# City of Albuquerque Stormwater Construction Site Inspection Report

ESC File No.	M15E054	Project Name:	Veterans Integration Center		
NPDES Id. No.	NMR1005M1	Location:	2701 Mulberry St SE		
8/2/2023	Owner	Contractor			
Operator	NM Veteran Integration Centers		Jaynes		
Contact name & title	Jerry Becker		Shad James		
e-mail	<a href="mailto:jerry@steomaticnm.com">jerry@steomaticnm.com</a>		<a href="mailto:shad.james@jaynescorp.com">shad.james@jaynescorp.com</a>		
Contact Phone #	505-833-7766		505-345-8591		
COA Inspector	Chancellor English		Start/End Time:	8:30am	
Construction Phase:	Grading, foundation				
Type of Inspection:	Regular	Storm Event	Post Storm Event >0.25"	311/Complaint	Follow Up
Weather at time of inspection?	Clear		Temperature: ~	85	
Estimated date of last storm 0.25" or greater	5/22/2023

ESC-1

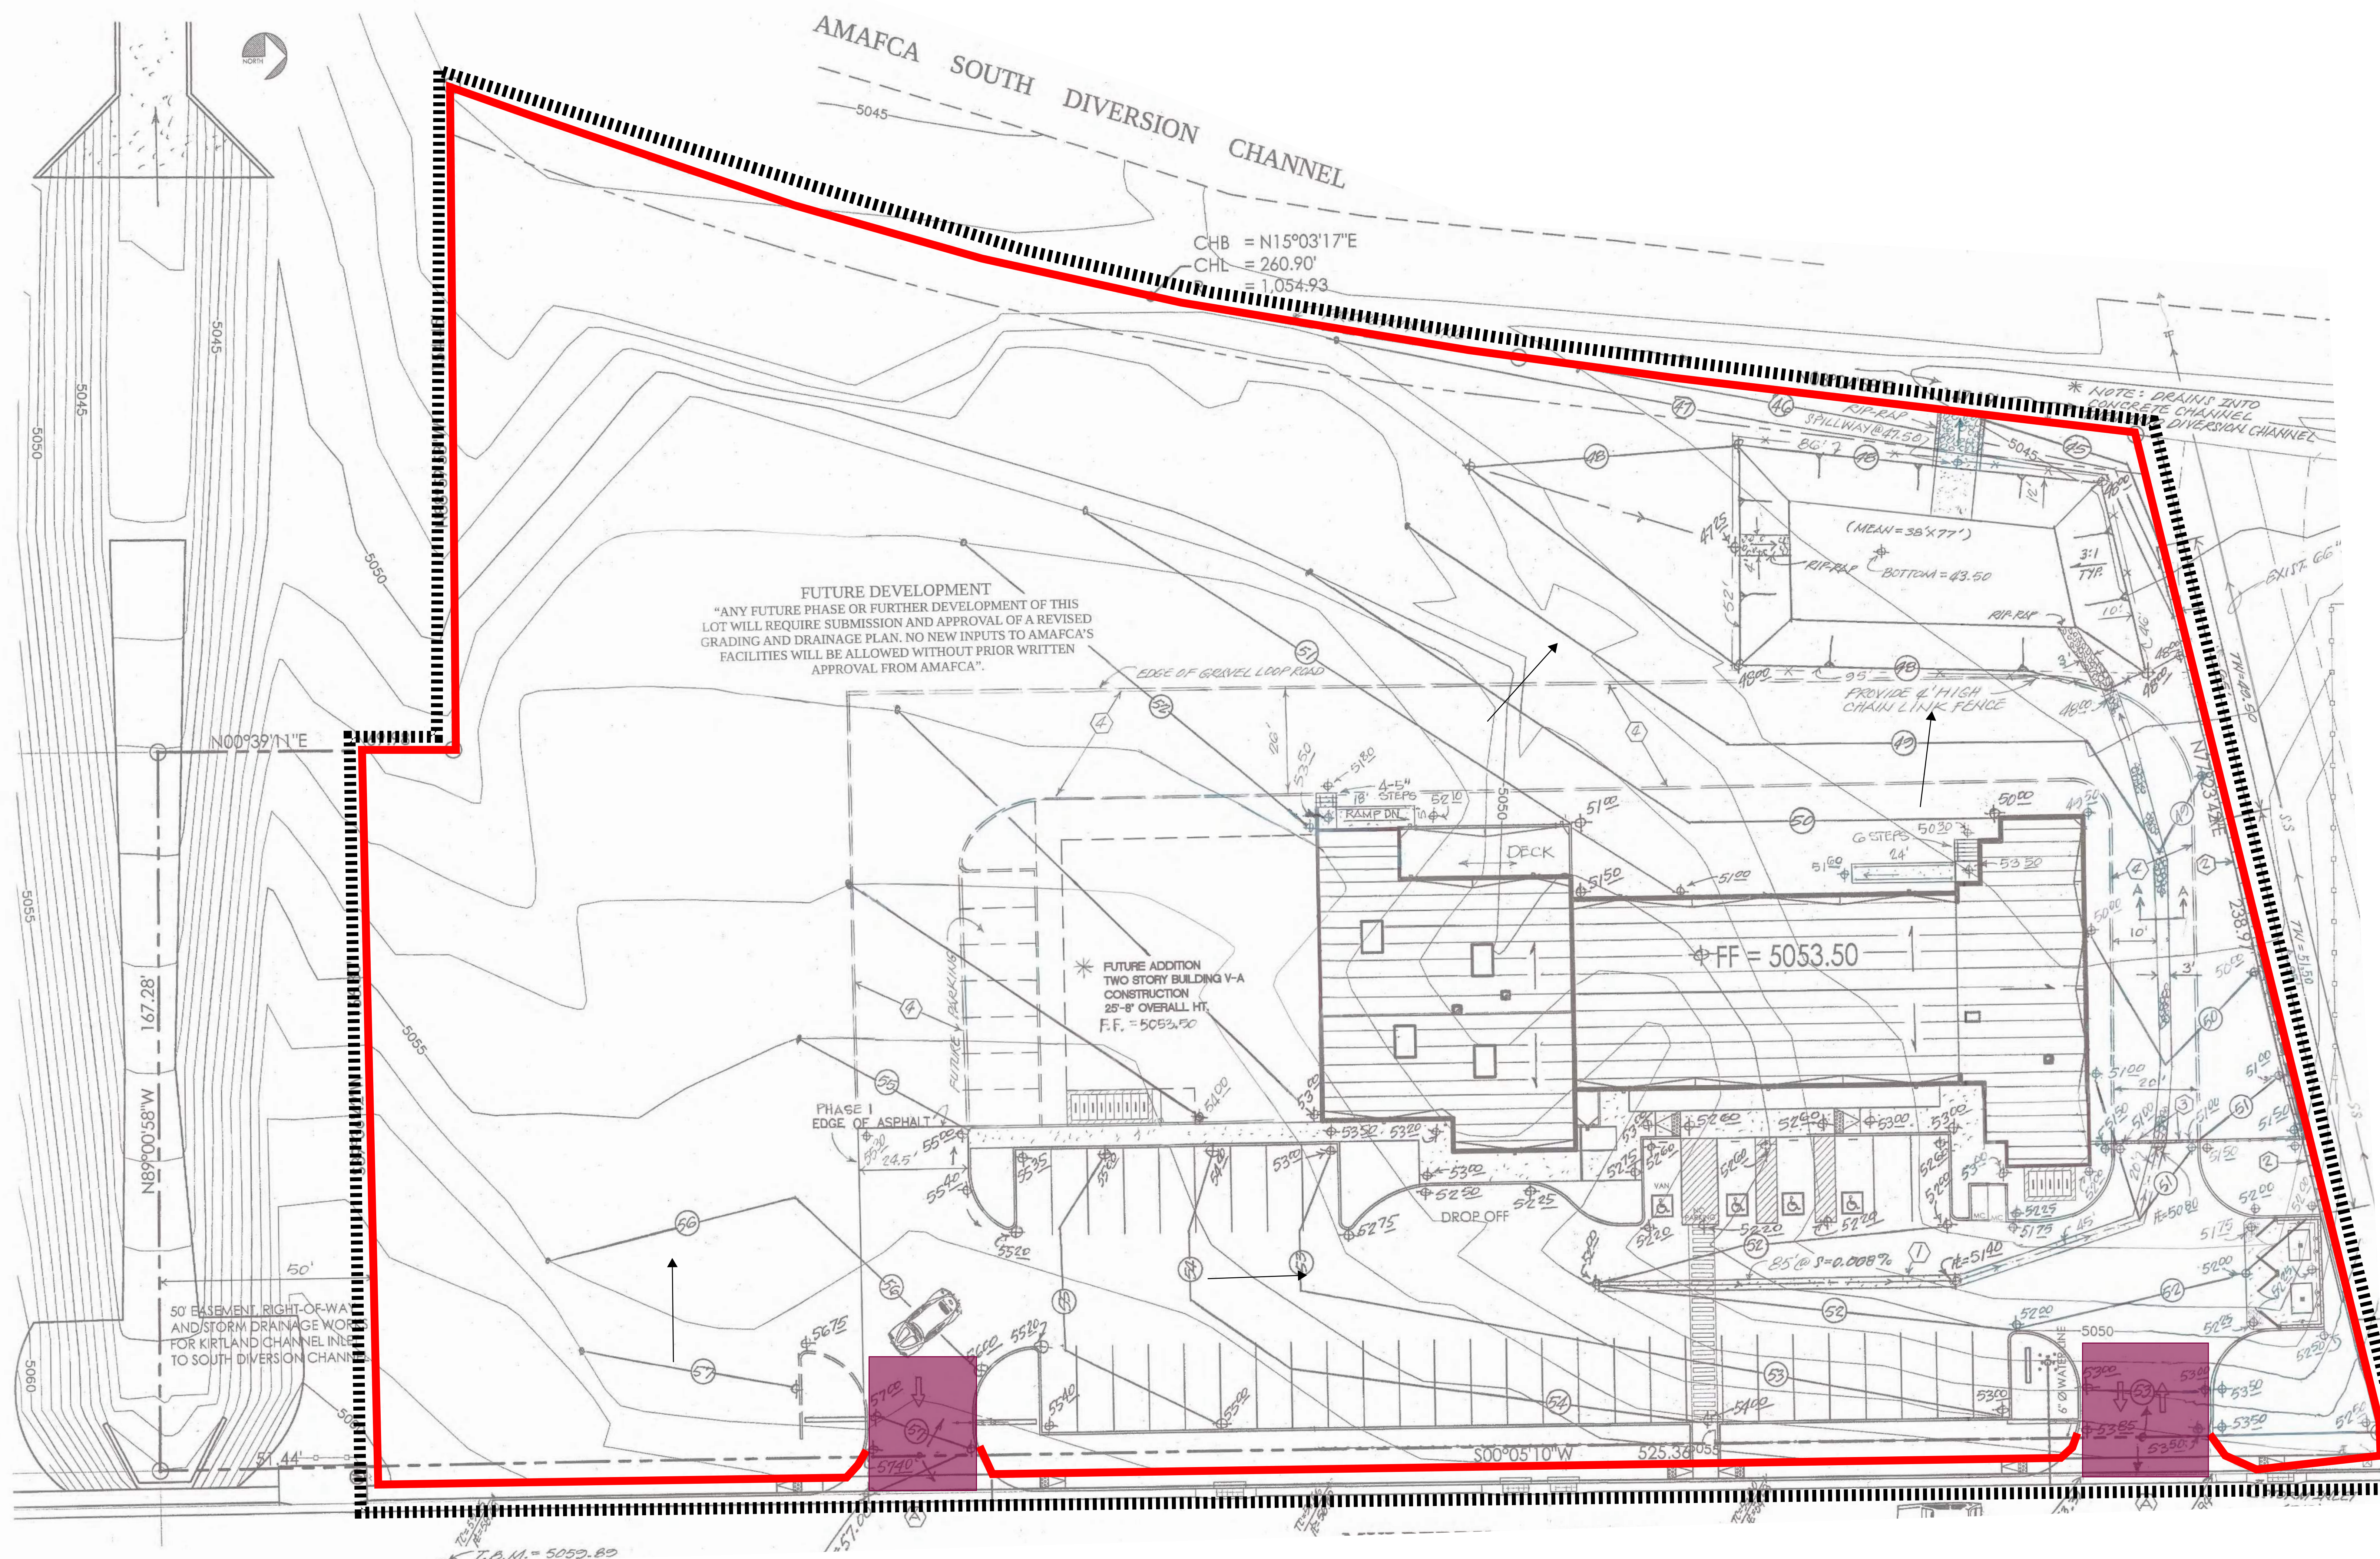
Item Number	Deficiency/ Corrective Action				
1	Washout was found in multiple areas on bare soil. The container provided for contractors to use is unacceptable, it is not leak-proof or lined and is inconvenient to use with tall sides. Required mitigation: CGP Part 2.3.4 requires you to direct wash water into a leak-proof container or leak-proof and lined pit designed so no overflows can occur due to inadequate sizing or precipitation. Do not allow liquid wastes to be disposed of through infiltration or to otherwise be disposed of on the ground.				
2	The SWPPP is incomplete and is not up-to-date. For both operators (Owner and Contractor), the SWPPP is missing both NOIs, certification signatures, and a delegation of authority. The SWPPP Map is not up-to-date, as it shows 2 construction entrances, and the self-inspection reports were unavailable. The Stormwater Team is missing a record of on-site training and a specific inspector. Stabilization plans also need to be included in the SWPPP. Required mitigation: Part 7.2 of the CGP lists the information that is required to be included in the SWPPP. This information includes the following: Identify the personnel (by name and position) that are part of the Stormwater Team, as well as their individual responsibilities, including which members are responsible for conducting inspections (CGP 7.2.2), SWPPP Certification in which your signatory must sign and date your SWPPP (CGP 7.2.10), A copy of your NOI (CGP 7.2.11.a), and a signed Delegation of Authority identifying a specific individual authorized to sign in lieu of the Operator (CGP Appendix G.11.2). You must modify your SWPPP, including the map, within 7 days whenever activities at your site are no longer accurately reflected in your SWPPP as per CGP 7.4.1.a. You must conduct a site inspection, at a minimum, once every 14 calendar days and within 24 hours of the occurrence of a storm event that produces 0.25 inches or more of rain within a 24 hour time period as per CGP 4.2. CGP Part 7.2.6.vii states that you must include stabilization measures in your SWPPP.

3	The permit coverage posting is missing the Owner's contact information. Required mitigation: CGP Part 1.5 requires you to post a sign or other notice of your permit coverage which must include a contact name and phone number (CGP Part 1.5.b).				
4	BMP Repair/maintenance of silt fence at corner of the lot. Required mitigation: Ensure all stormwater controls are maintained and remain in effective operating conditions.
